## MMC Visitor Garage and East Tower Project - Final Traffic Comments

Hi Jean – the following outlines my Final Traffic comments as a status update of my January 18, 2018 initial review.

TOP TWO FLOORS TO BE TAKEN OUT OF SERVICE (TO BE DISCUSSED WITH MMC) MAY 2019

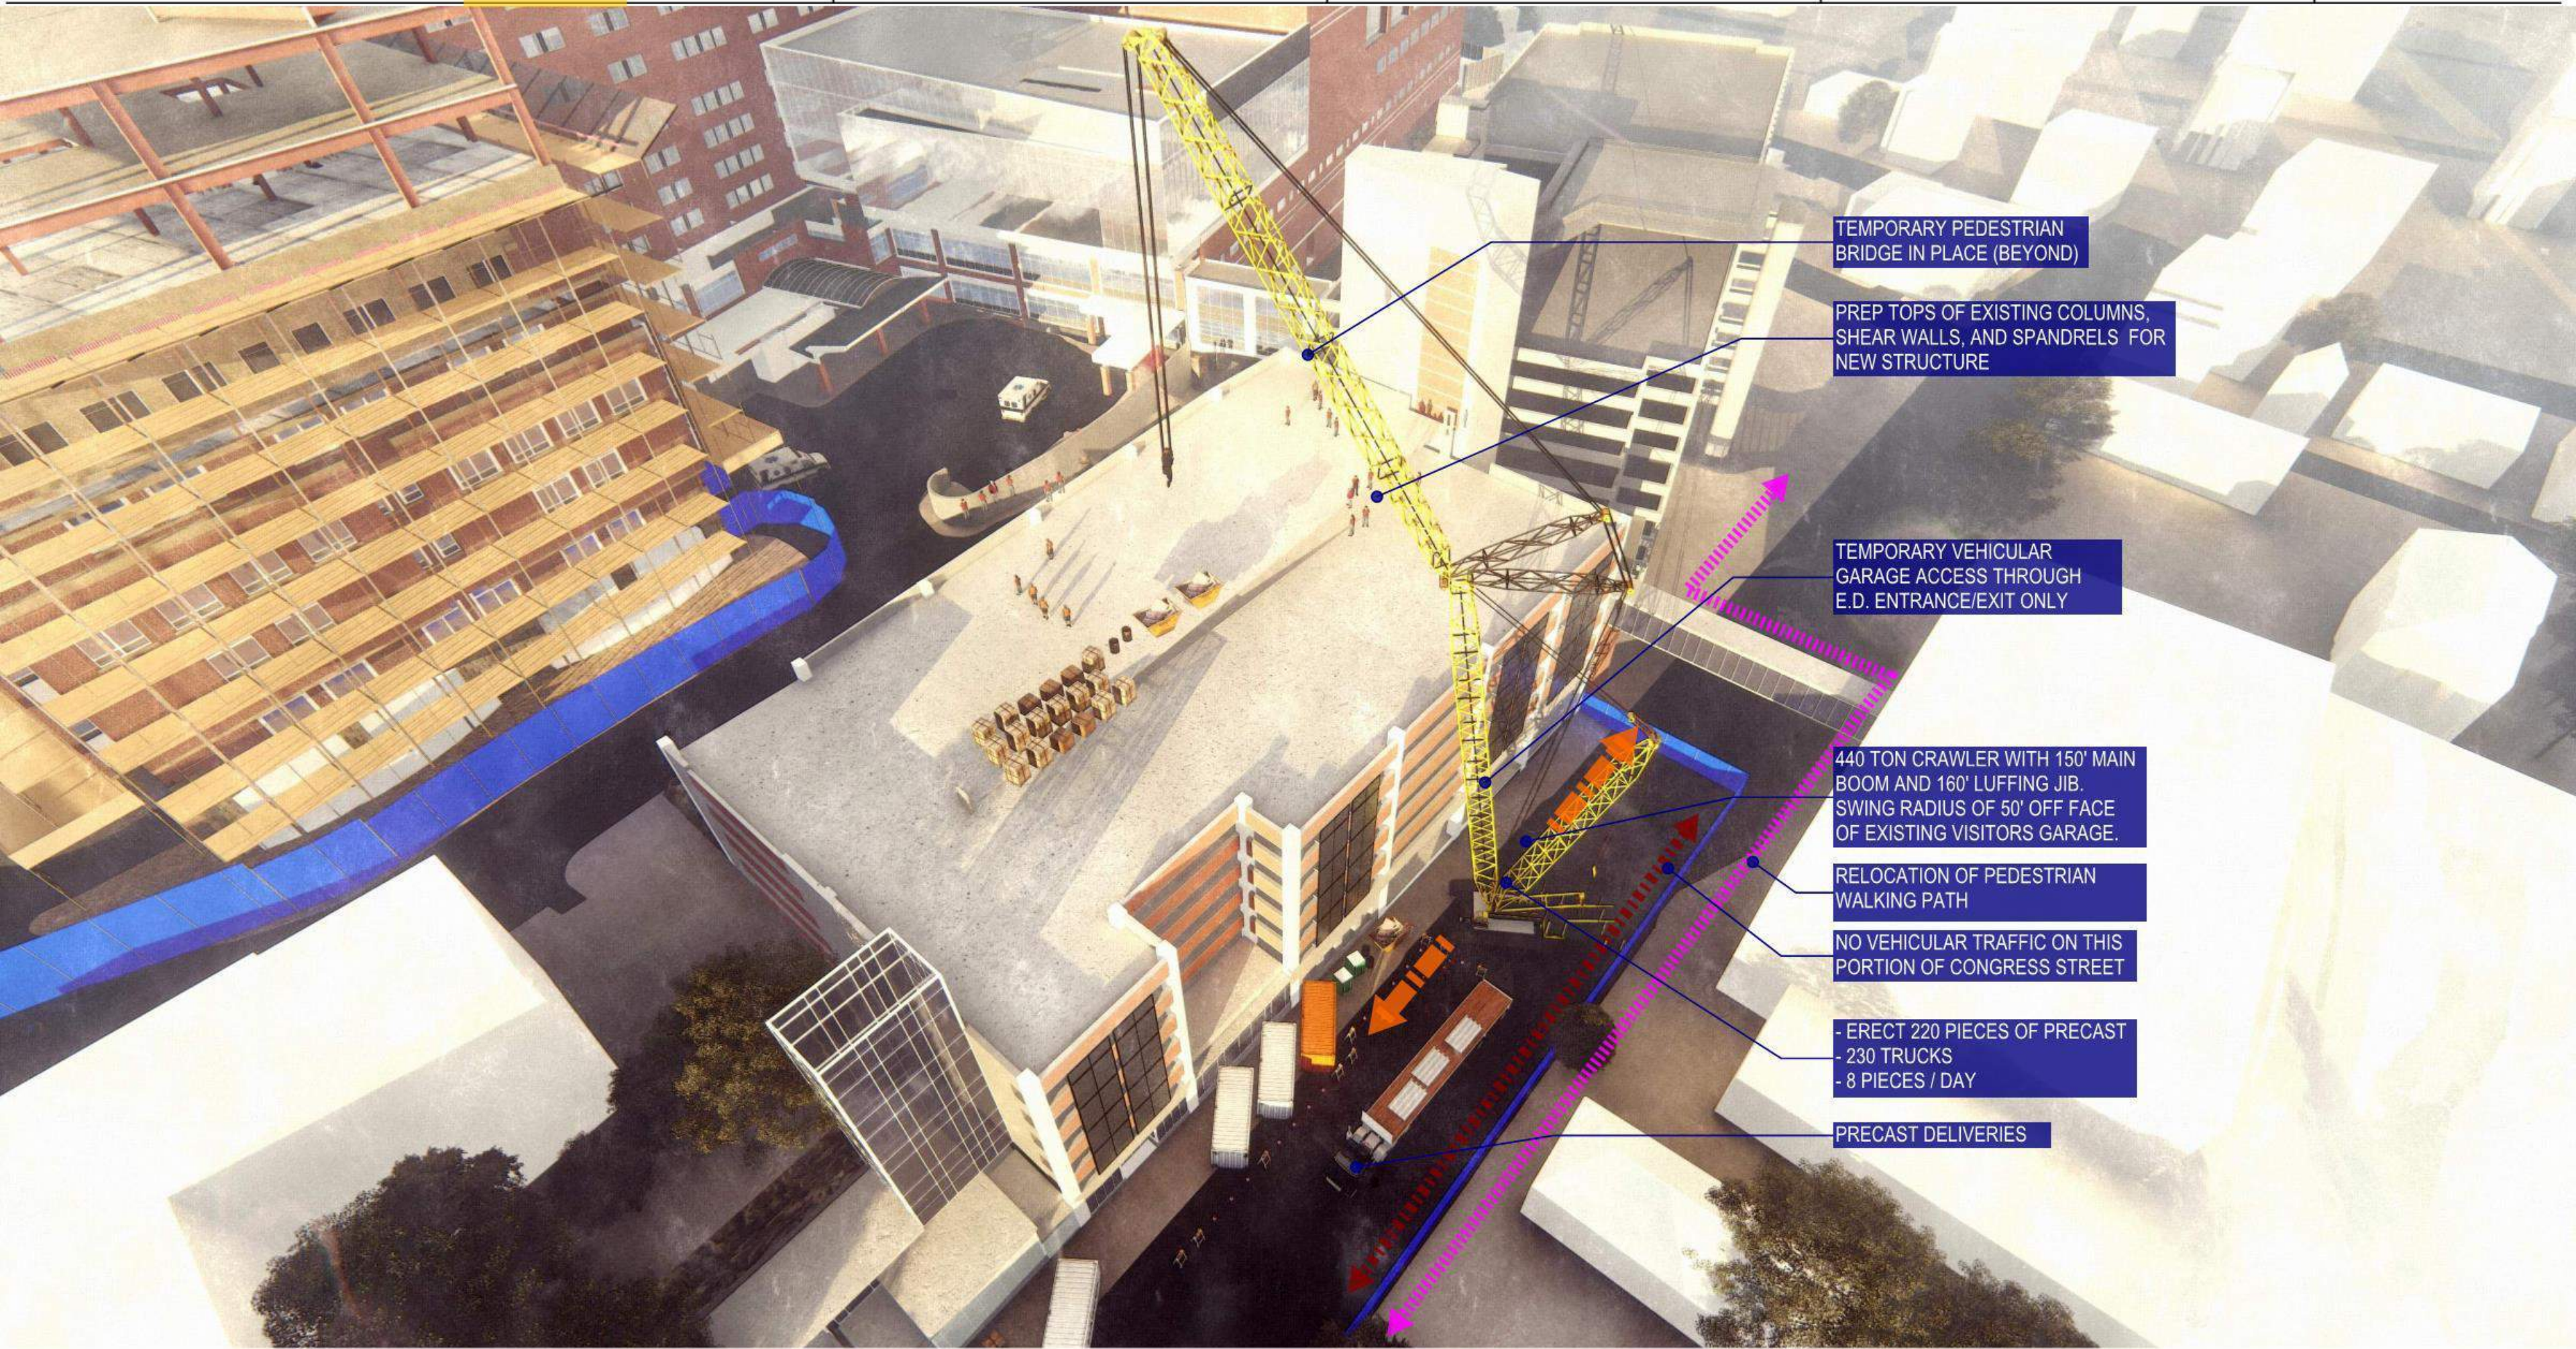
- During the construction of the Visitor parking garage, the top two floors of the existing garage will be taken out of service. The applicant should provide parking management details addressing the loss of the noted parking spaces.

**Status: The Applicant has provided a parking management plan for addressing the loss of parking spaces. I have no further comment.**

[ East Towers ] Logistics Plans and Studies

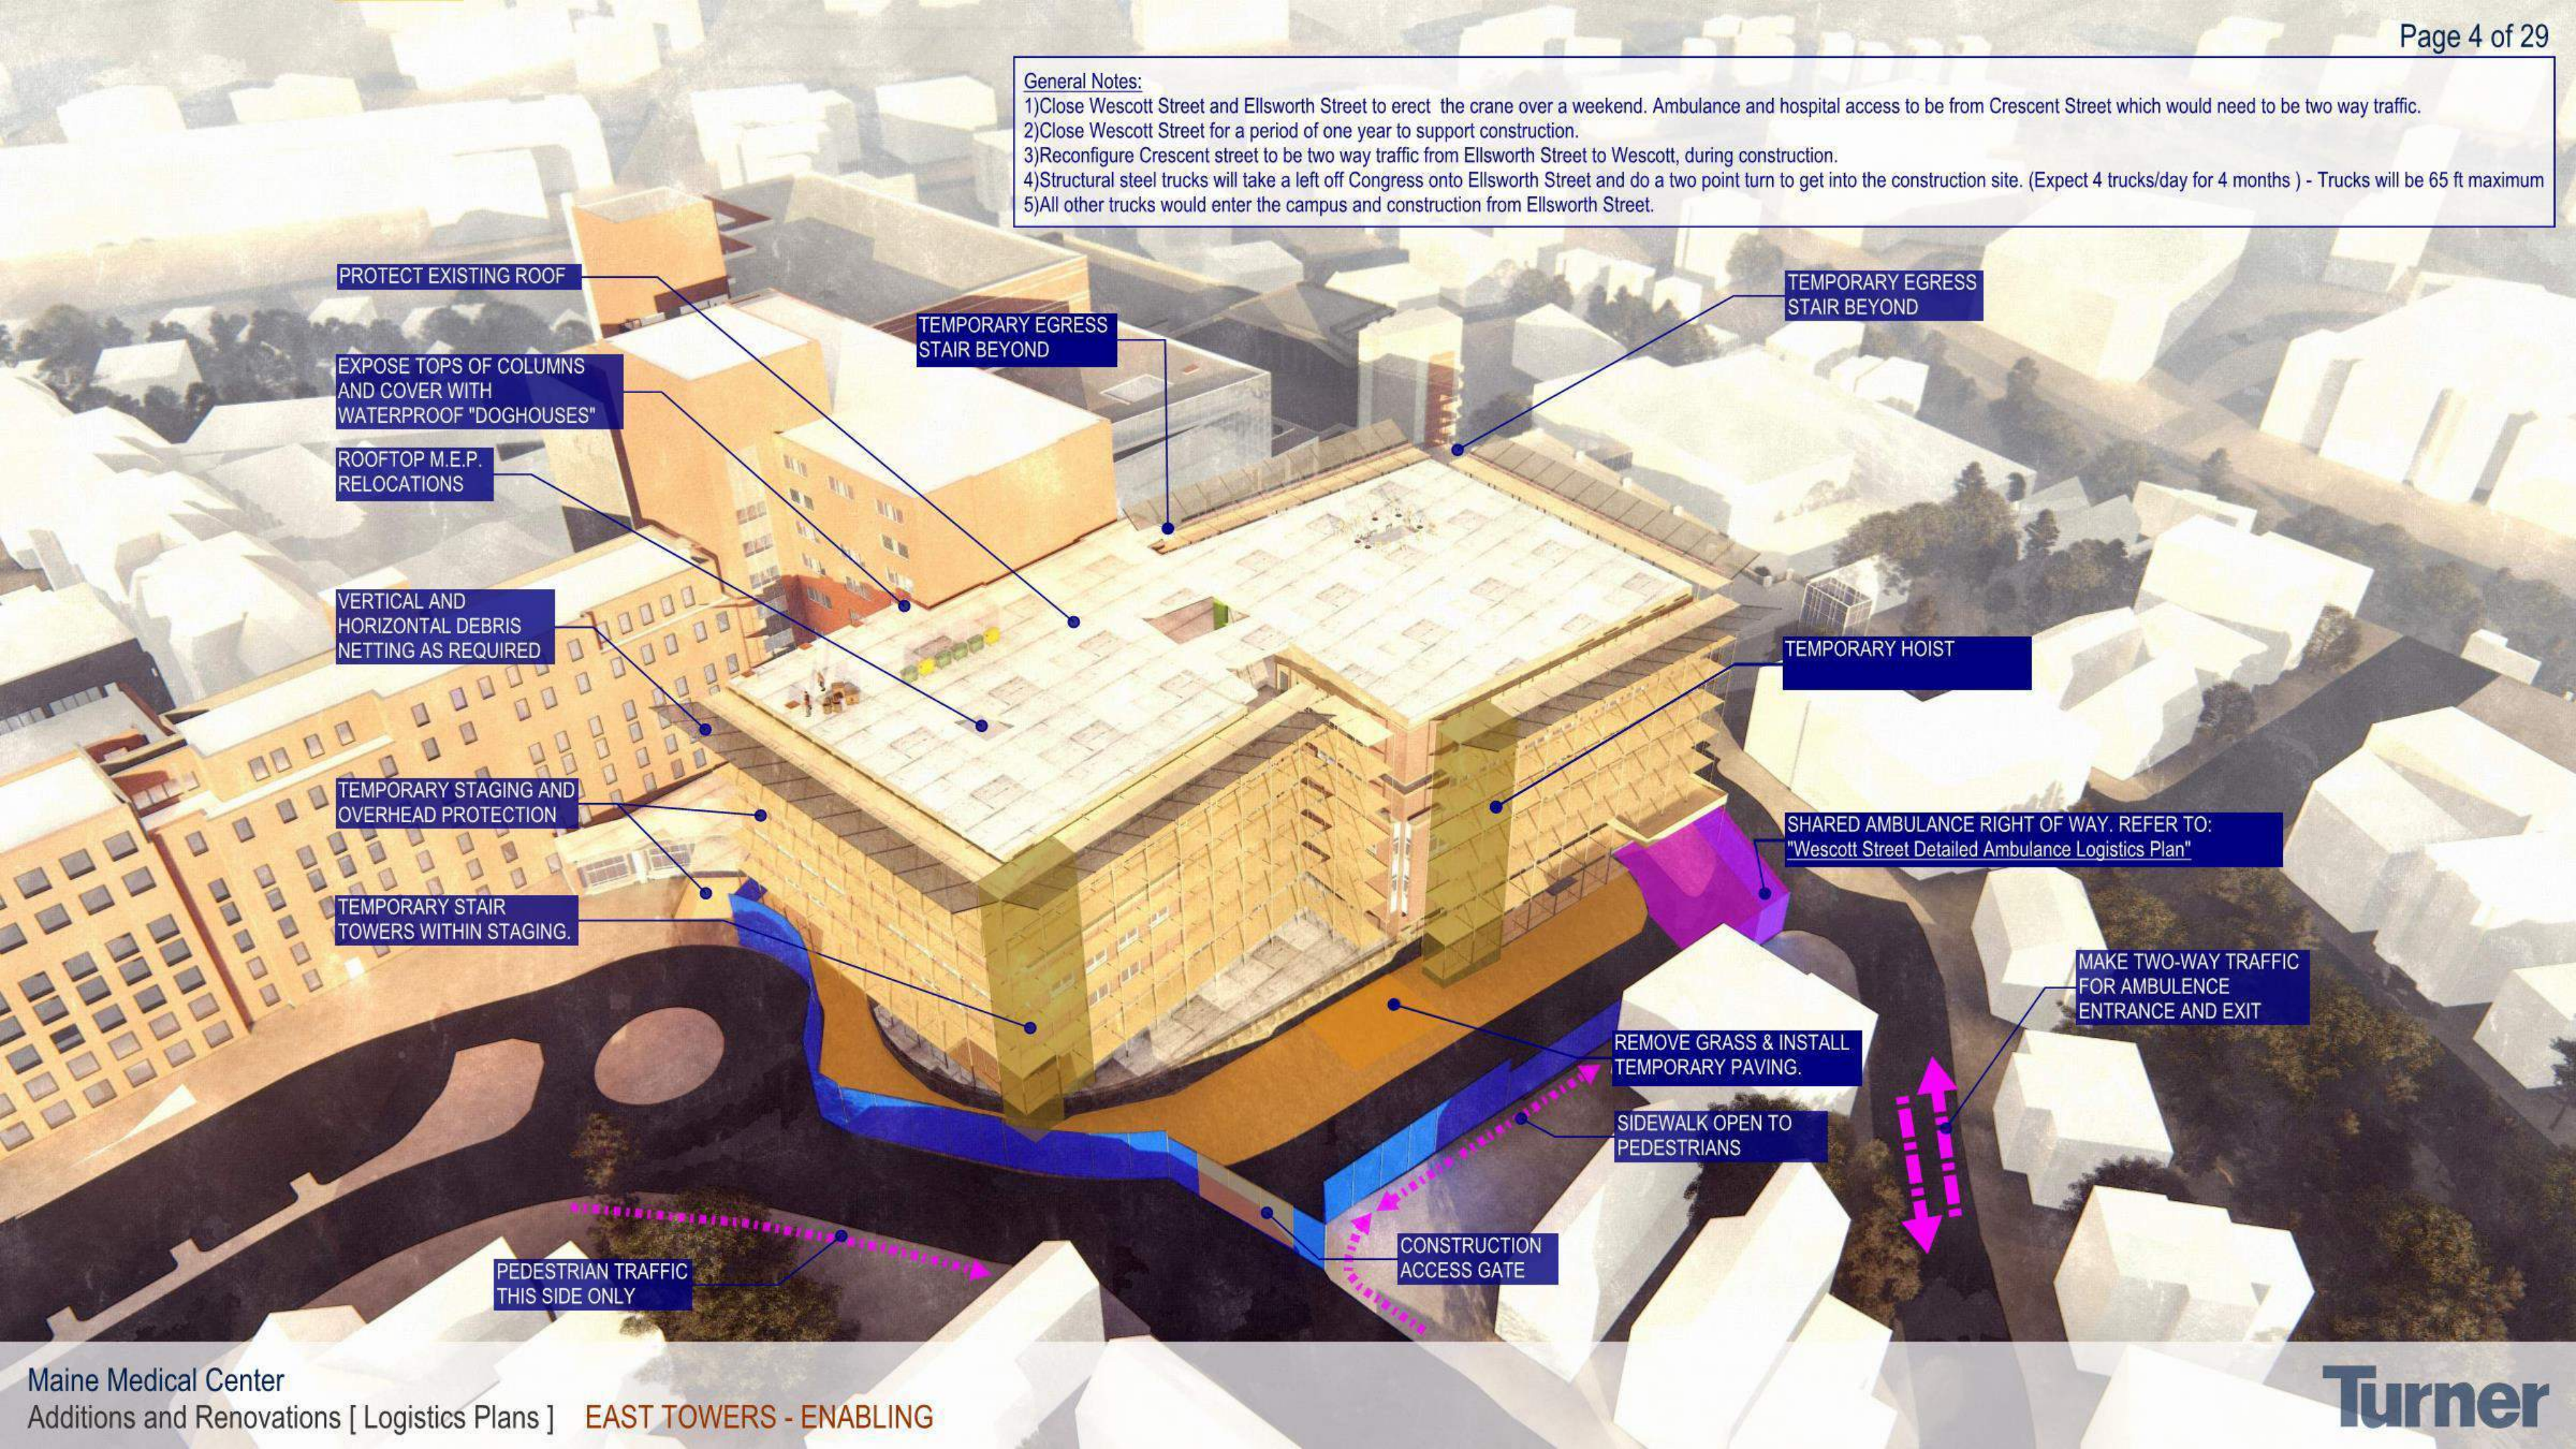
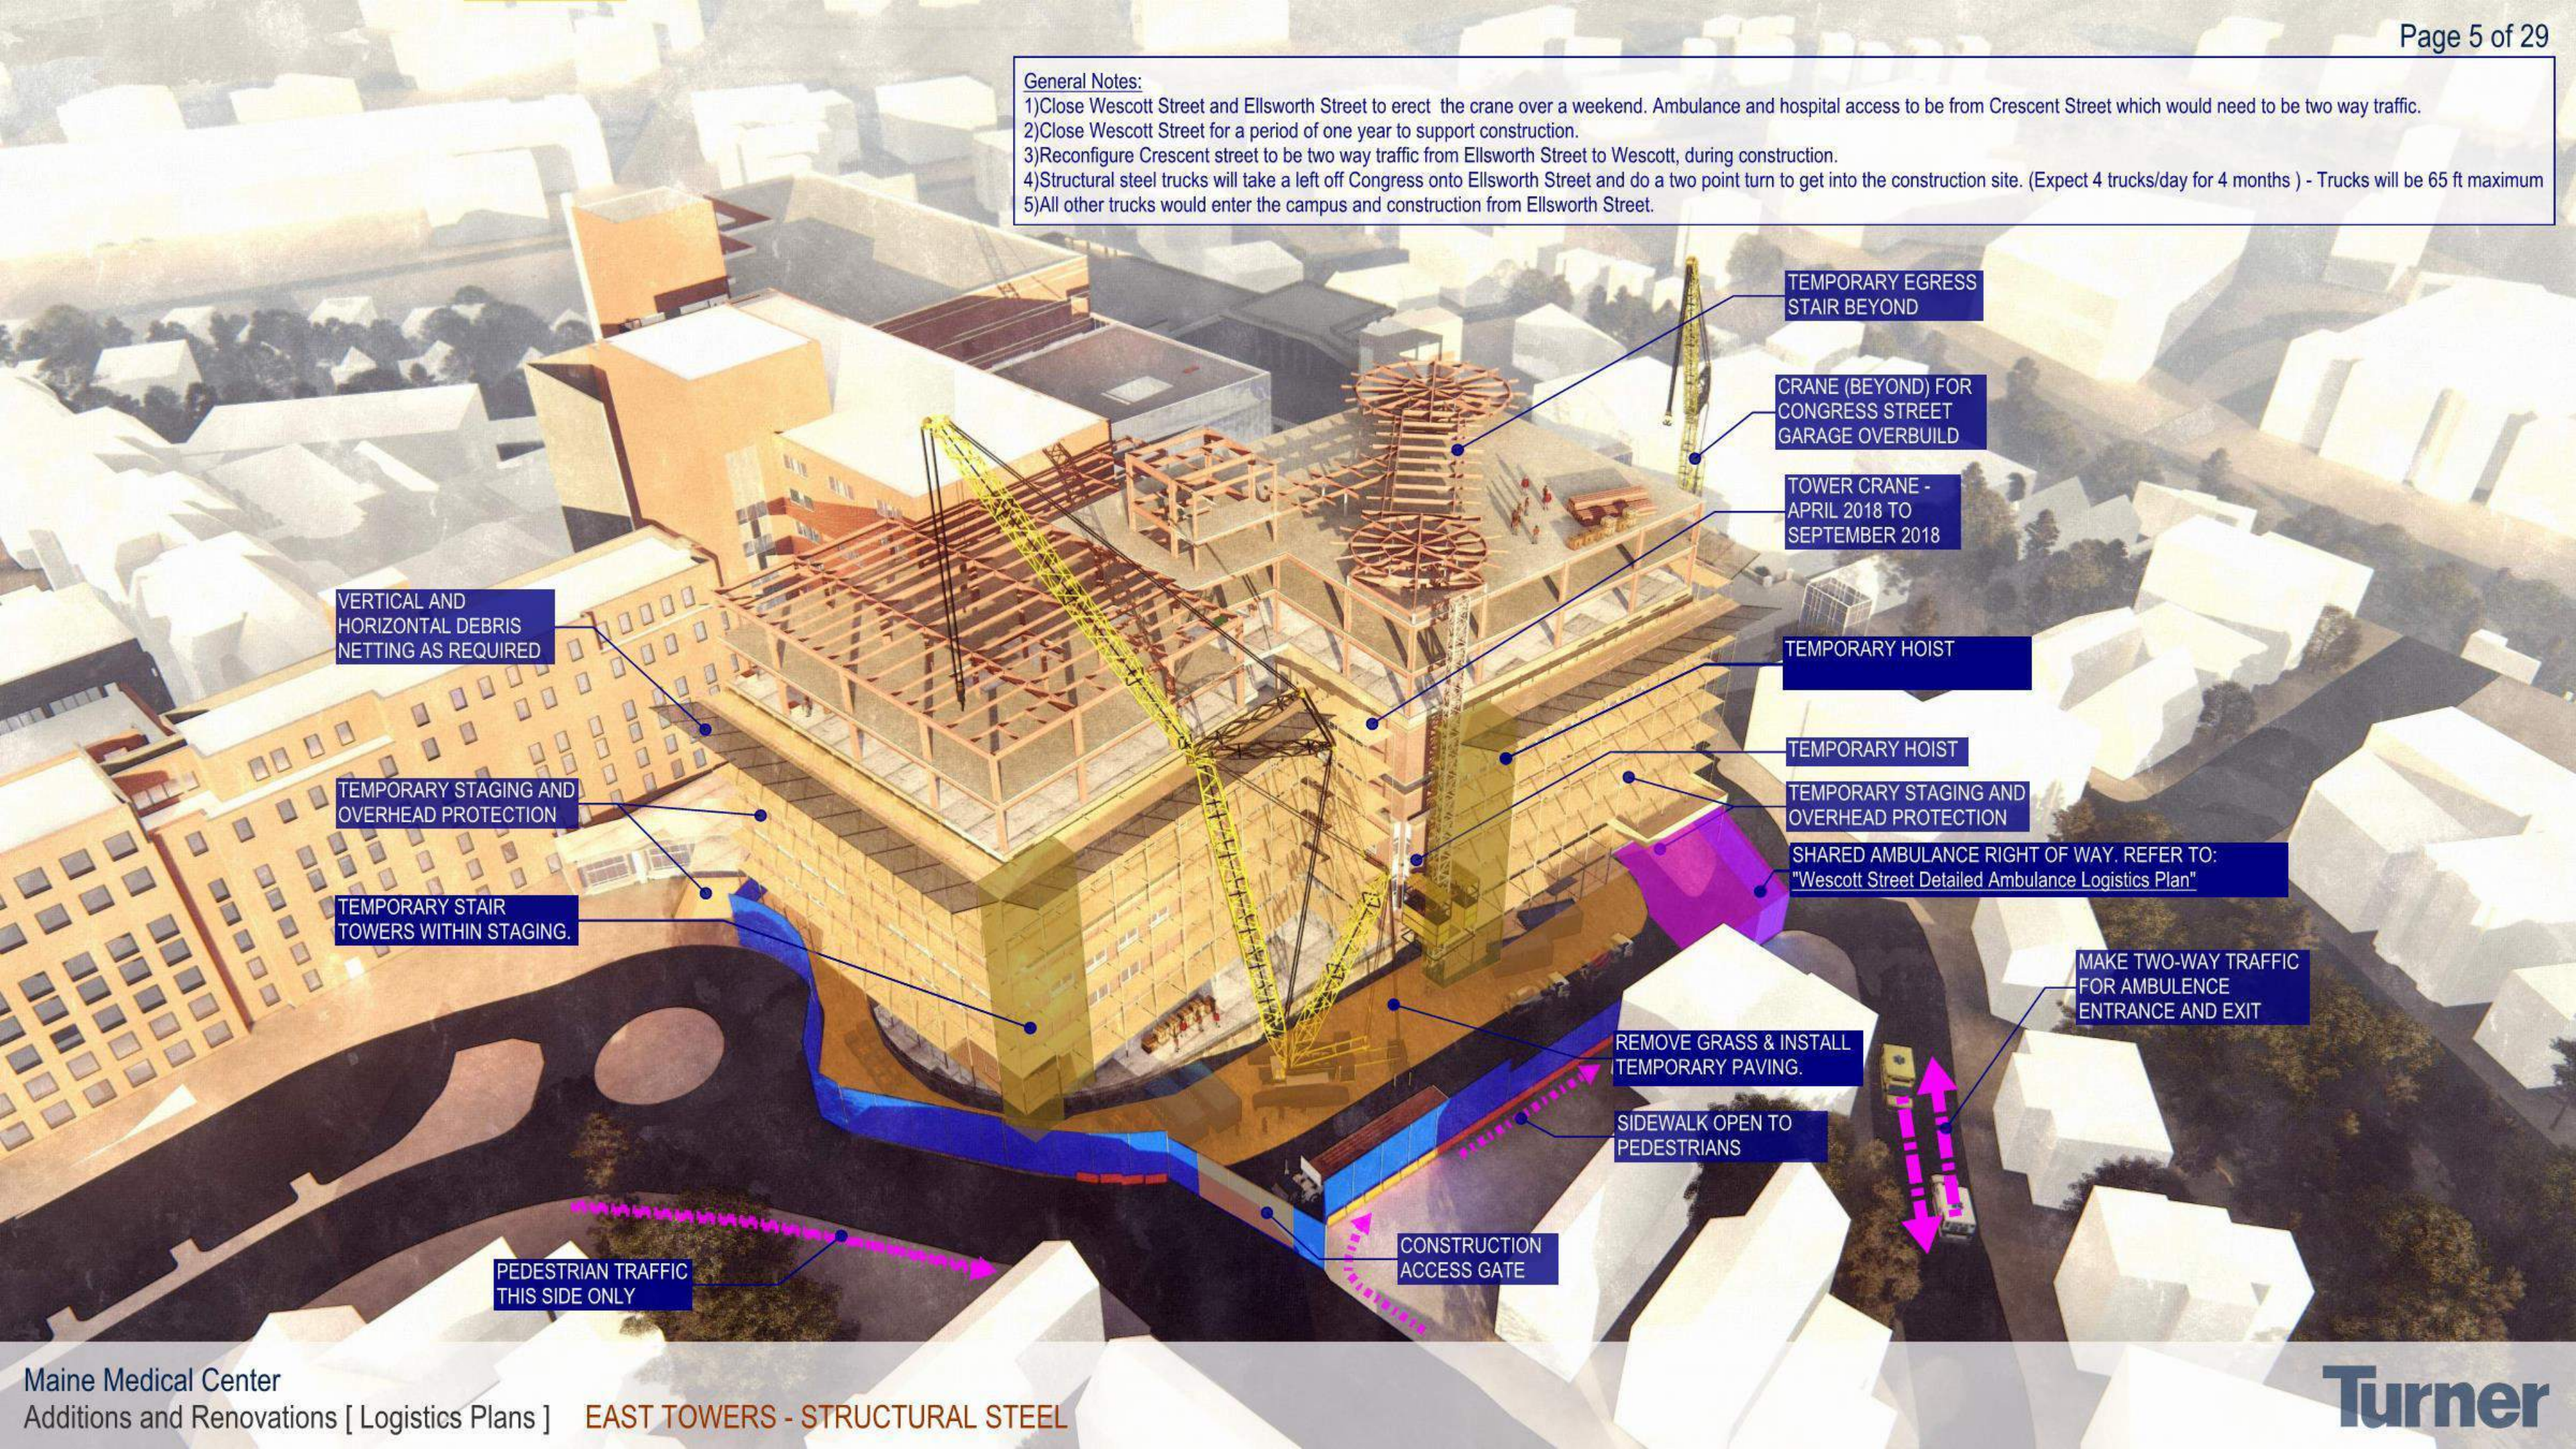
- The following are initial East Tower Traffic Control Plan comments:
  - The City does not support the conversion of Ellsworth Street to two-way flow between Congress Street and Crescent Street. The applicant has noted this to be acceptable. The plans should be revised to reflect this change.
  - It is unclear if the bump out at the Crescent Street/Wescott Street intersection is to be removed. If it is to remain, vehicle turning templates

should be provided for review and approval.

- Detailed routing and vehicle turning information for truck deliveries shall be provided for review and approval.
- It is my understanding that the Fire Department will be providing comments regarding concerns for Emergency Department vehicle access.
- Specific parking information shall be provided as it relates to fully understanding current on-street parking usage, location of on-street parking prohibitions, and how existing properties parking needs will be addressed given loss of on-street spaces.

**Status: Significant review and coordination has occurred in conjunction with the Construction Management Plan including vehicle/truck detours during the closure of Congress Street. I find the current plan to be acceptable with the noted Conditions of Approval.**
